Application No: AB/101/21/HH
Site Address: 43 Torton Hill Road Arundel BN18 9HF
Description of works: Erection of two storey side/rear extension, porch to front with associated alterations to fenestration and drainage works.

Thank you for your internet representation made on 28th September 2021 which has been recorded as an objection with the comments as follows:

AB/101/21/HH - 43 Torton Hill Road Arundel

FIRST FLOOR PLAN
AS PROPOSED
1:50

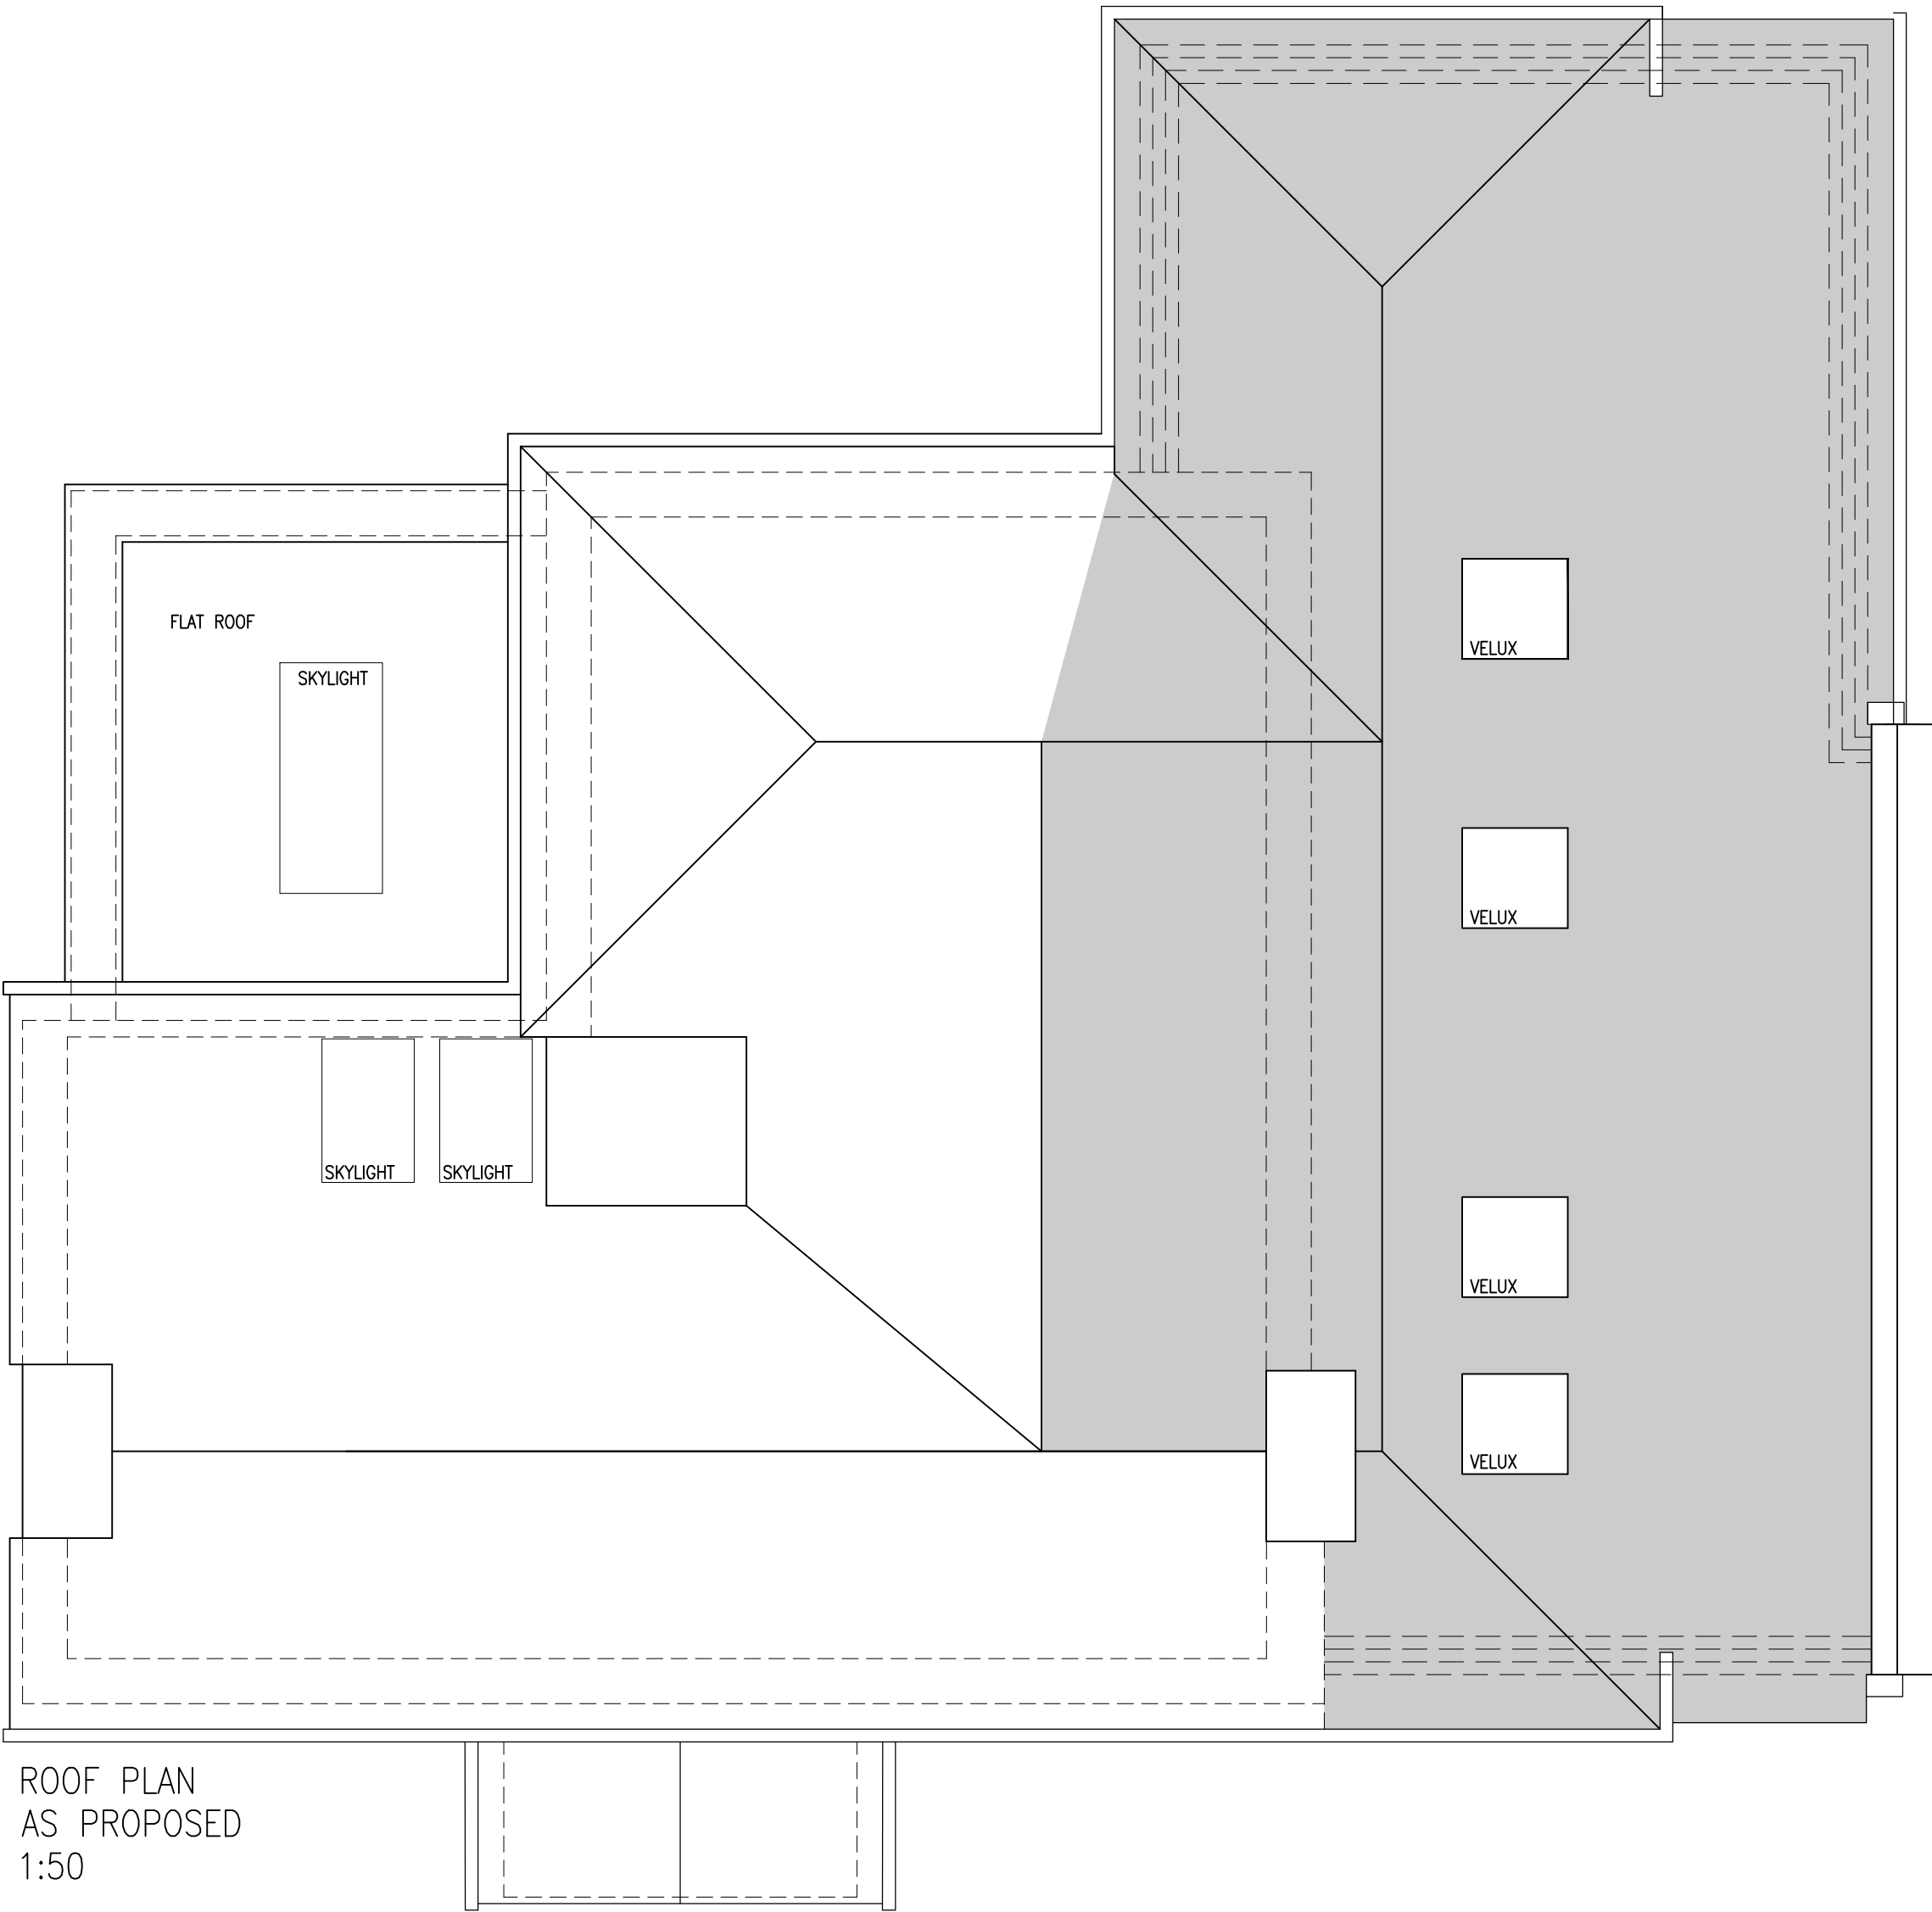
- Side Extension - Objection to the addition of Velux windows along the side extension as this will impact on the privacy of 45 Torton Hill Road. There are two Velux windows at 45 Torton Hill facing directly opposite the party wall for the proposed extension. Due to the proximity between the two houses this will compromise the privacy because four Velux windows on the proposed side elevation are of a size, height and angle that will allow direct visibility into the existing Velux windows (lavatory and family bathroom) of 45 Torton Hill, compromising privacy. In addition, windows will allow direct observation into both side and rear patio gardens removing the only private space in the garden for number 45.

- Side Extension - The intended works clearly encroach on the existing party wall shared by 43 Torton Hill and 45 Torton Hill. For the record, of concern to the owner of number 45 it seems that the party wall will be heightened and modified, terminating in a parapet at the gable. Therefore, as the owner of number 45 I would require provision to drain rainwater runoff without any encroachment on / or over the parapet for number 45. Runoff to be contained/ drained to existing points under Part G (2015) Building Regs.
